Re: Reference Number 09_0028 - Environmental Assessment for a Proposed Cultural Events Site at Tweed Valley Way and Jones Road, Yelgun - Byron LGA

Submission to the Proposed Cultural Events Site at Tweed Valley Way and Jones Road, Yelgun – Byron Shire LGA

Ref Number: 09_0028
Date: 19 November 2010

Illustration | **1.1**
Typical Design
Roads and Laneways

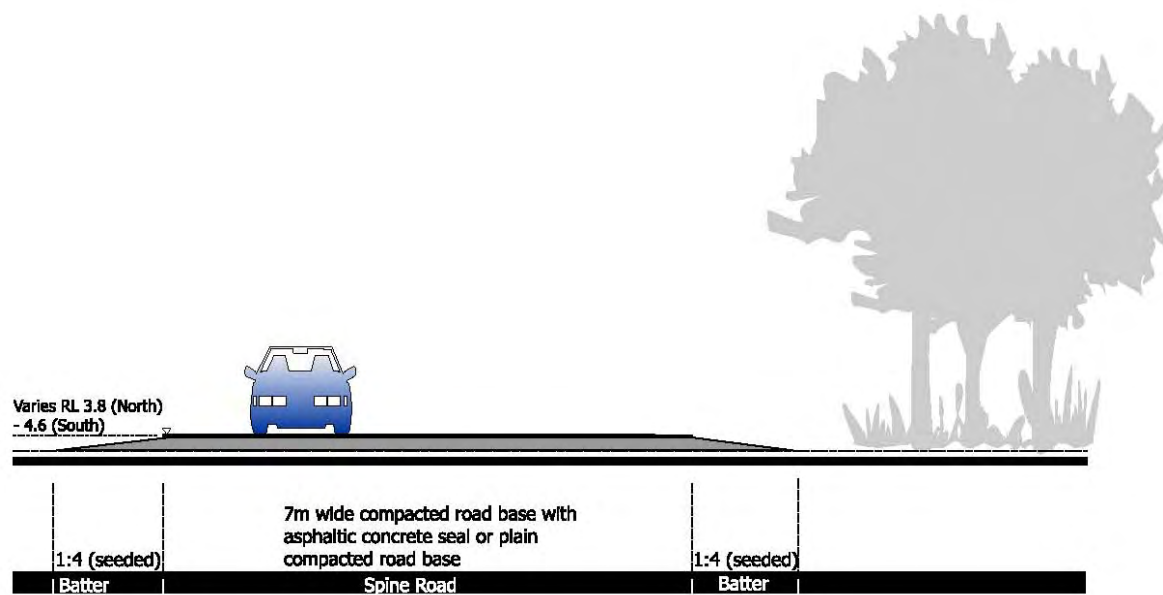
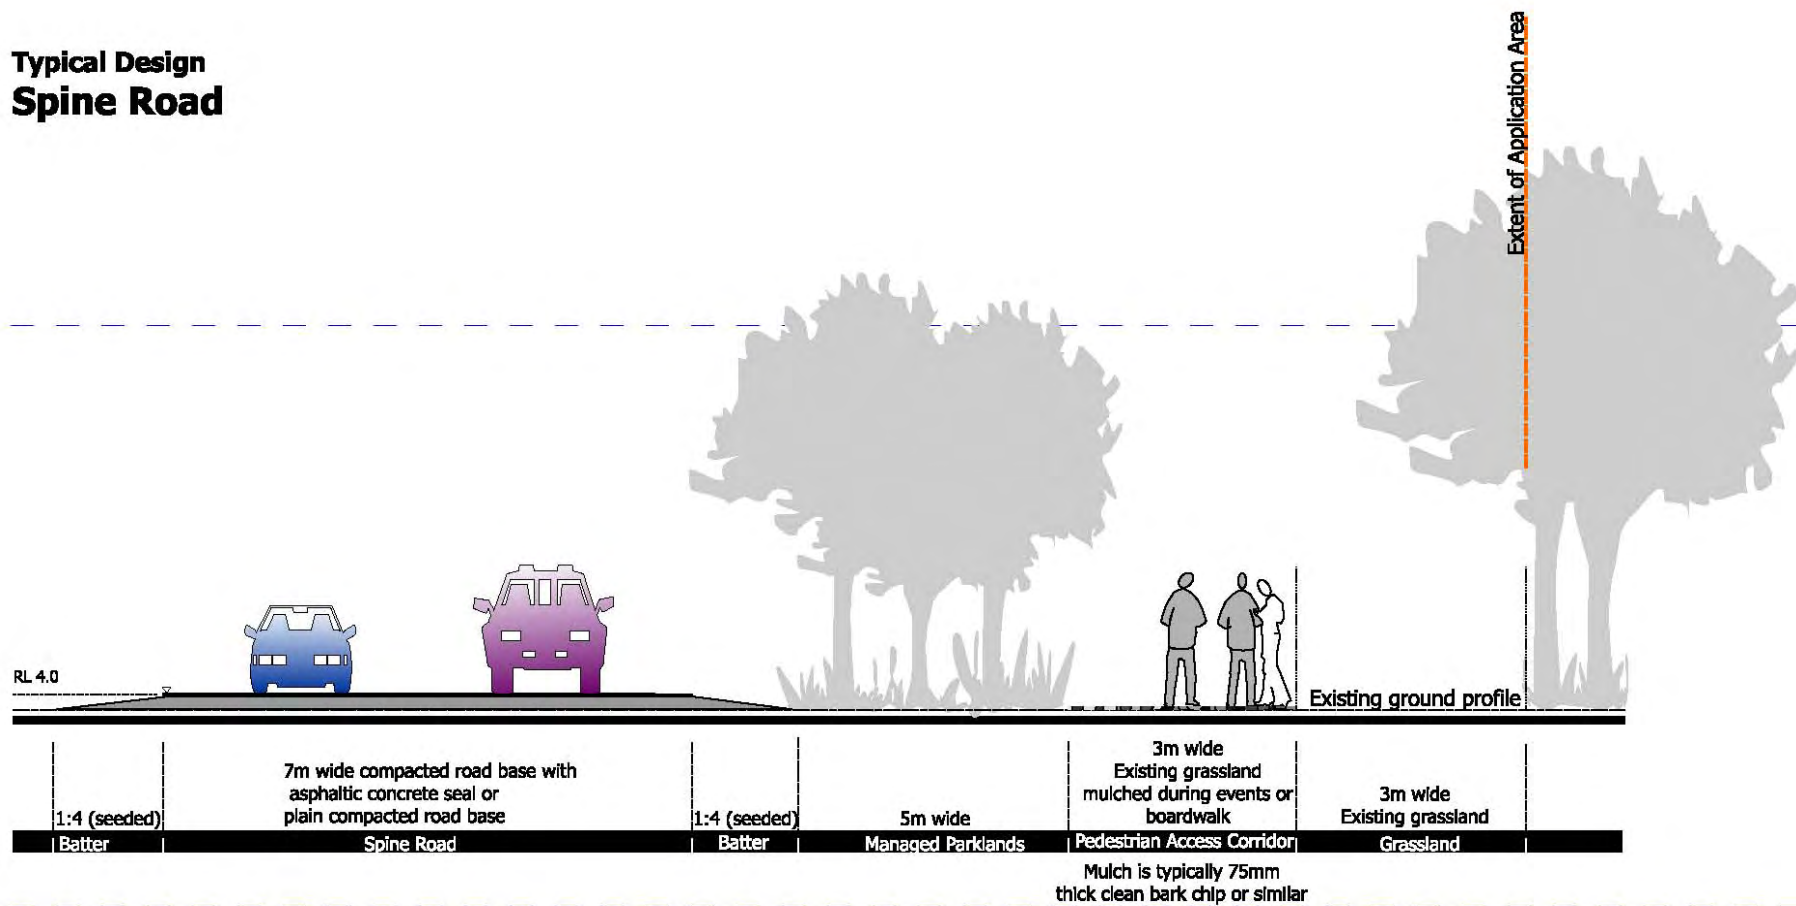
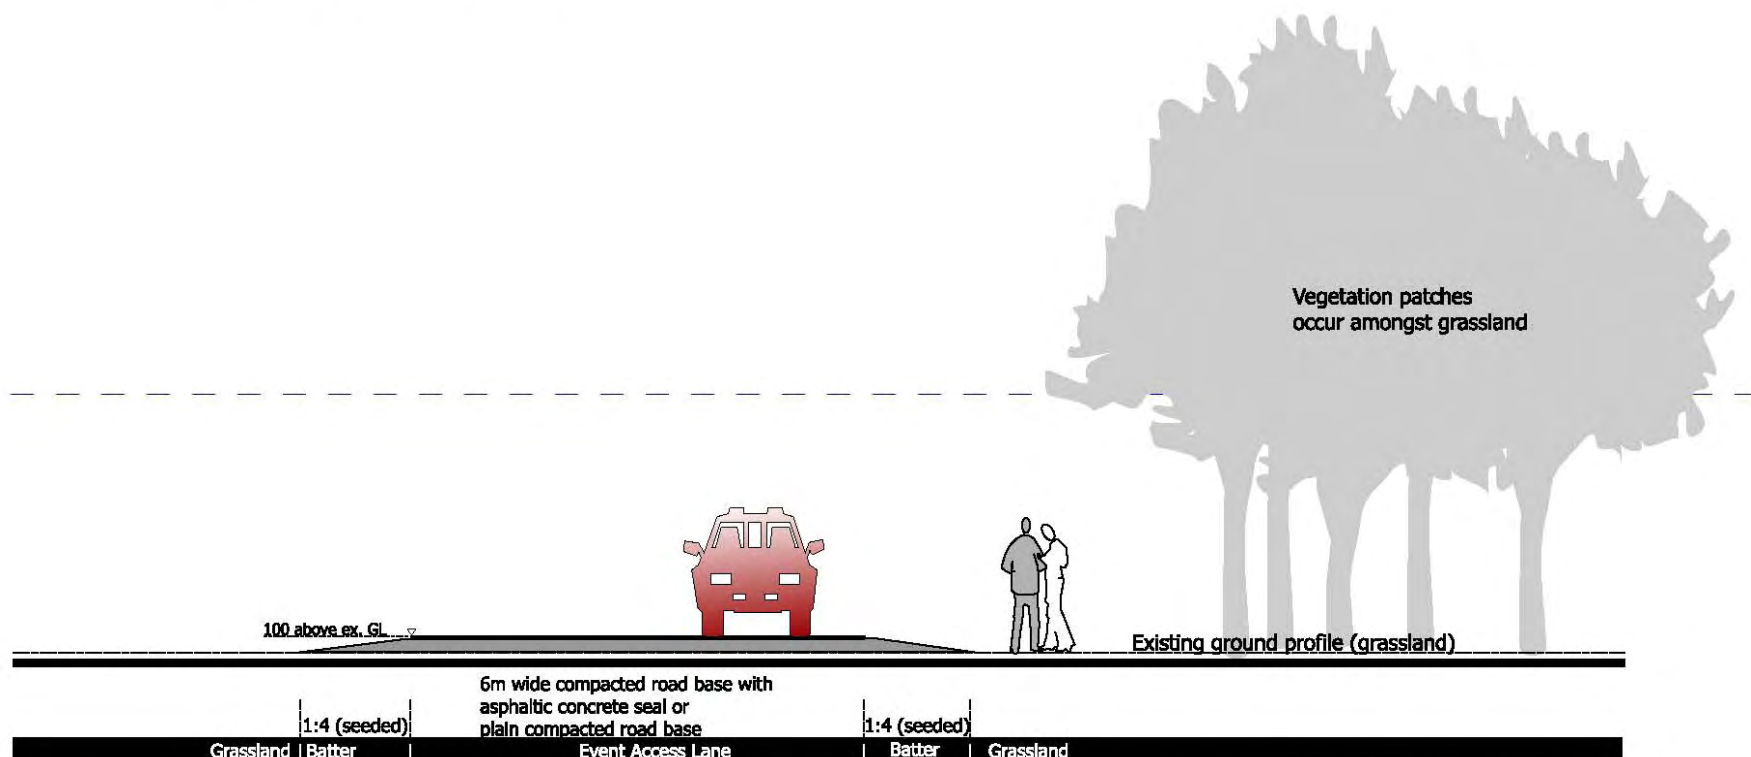
In order to carry out the excavation of Jones Road ridgeline, the proponent is proposing to remove important habitat and native vegetation, including an important hollow stag, which is critical habitat for a wide range of hollow dependent species. This proposal contradicts the comments and findings of Commissioner Cleland who stated... *"To ensure proper consideration is given to wildlife corridor values all existing vegetation should be*

retained. This is particularly evident for the western end of Jones Road..." (Cleland, 1997). The overall cumulative impact of the removal of native vegetation and habitat proposed for upgrading the western end of Jones Rd and for the 'cut and cover tunnel' also at the western end of the corridor will be significant. The wildlife corridor at this location is very narrow and simply cannot sustain further impact.

It can also be argued that the proposed Spine Road and the widening of Jones Road would not serve to protect the existing vegetation in the Zone and is not compatible with the Zone 7(k) objectives. It can also be argued that the proposed Spine Road and widening of Jones Road are unnecessary for any farming use of the site given that good access connectivity already exists between the southern and northern parts of the site via Tweed Valley Way and Jones Road. That is, the vegetation and landform of land in the Zone 7(k) can be protected without compromising the farming use of the site – as was evidently found by the prior ownership.
